## Review of written answers provided by Roxhill

Figure 1: Northampton Gateway: Diagrammatic track layout

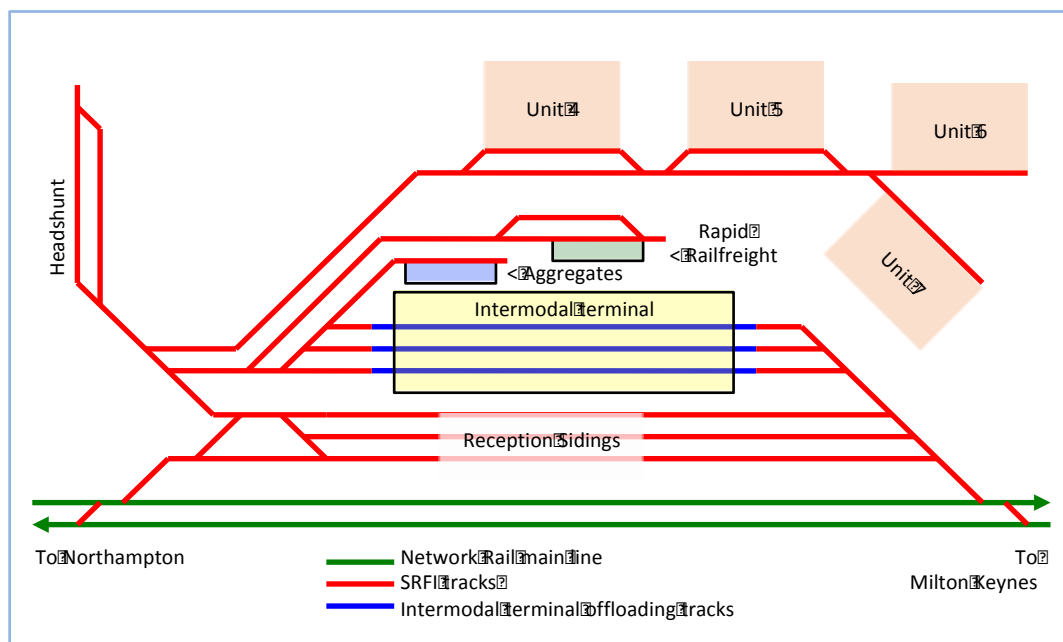
| Written question | Roxhill answer   | My response   |
|------------------|--|---|
| 1.11.31          | (ii) The assumption of 16 trains is made for all purposes in the ES.   | Referencing Roxhill's Rail Report (Document 6.7) Figure 1, this suggests that no allowance has been made for express freight trains.  |

Figure 12: Secondary catchments of 50 km around Birch Coppice, Hams Hall, East Midlands Gateway, Birmingham Freightliner, DIRFT and Northampton Gateway

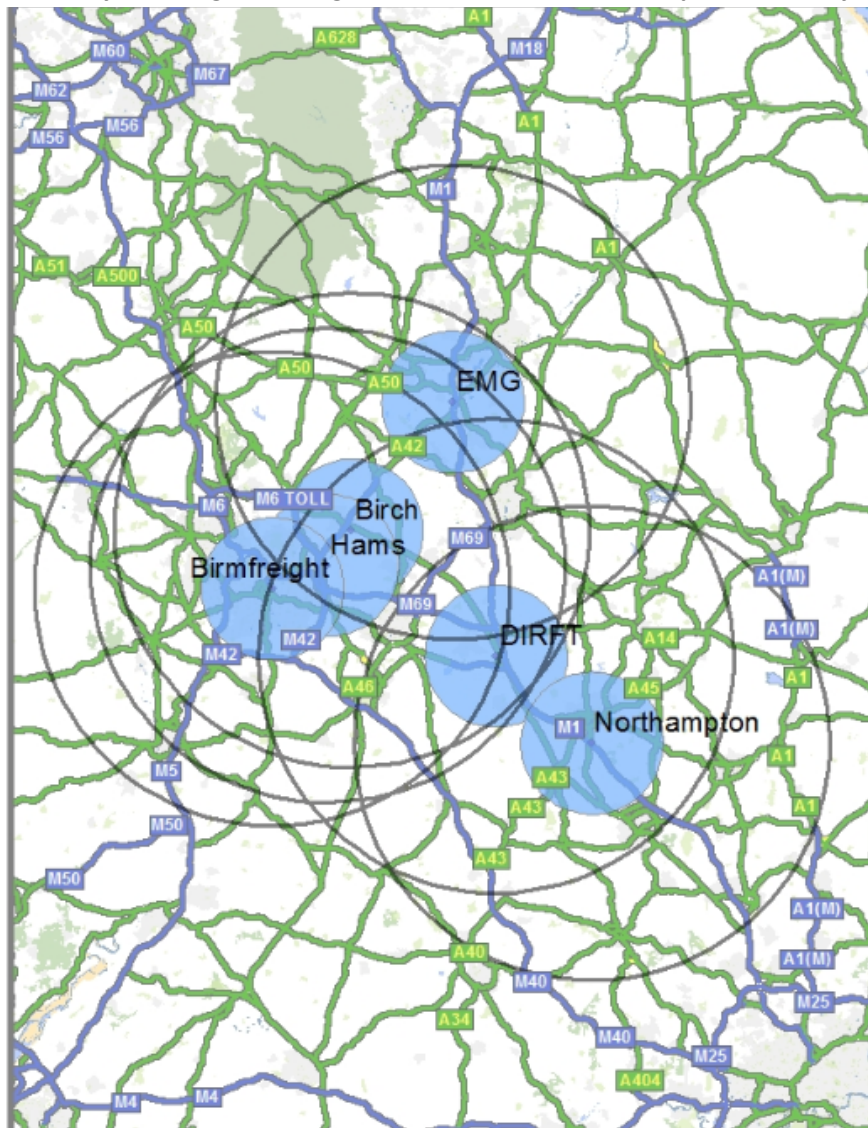
| Written question | Roxhill answer  | My response  |
|------------------|---|--|
| 1.0.28           | Section 7.0 and 8.0 of the Market Analysis Report seeks to explain the markets that will be served by the   | Figure 12 in Section 7 shows a considerable amount of overlap between the areas covered by the SRFIs, and does not demonstrate the need for Northampton  |

| Written question | Roxhill answer   | My response  |
|------------------|--|--|
|                  | Northampton Gateway Rail Freight terminal. This explains that some of the Northampton Gateway core and secondary market areas are not currently well served by an existing SRFI and therefore without Northampton Gateway the use of rail freight in this market area will be constrained. | Gateway in addition to DIRFT. The applicant appears to have overlooked the NPSNN paragraphs 2.50, 2.54, 2.56, 2.57 and 2.58, which illustrate the government's aim of a <b>national</b> network of SRFIs. The East Midlands is already well supplied with SRFIs in contrast to the North West, Yorkshire and West Midlands.  |
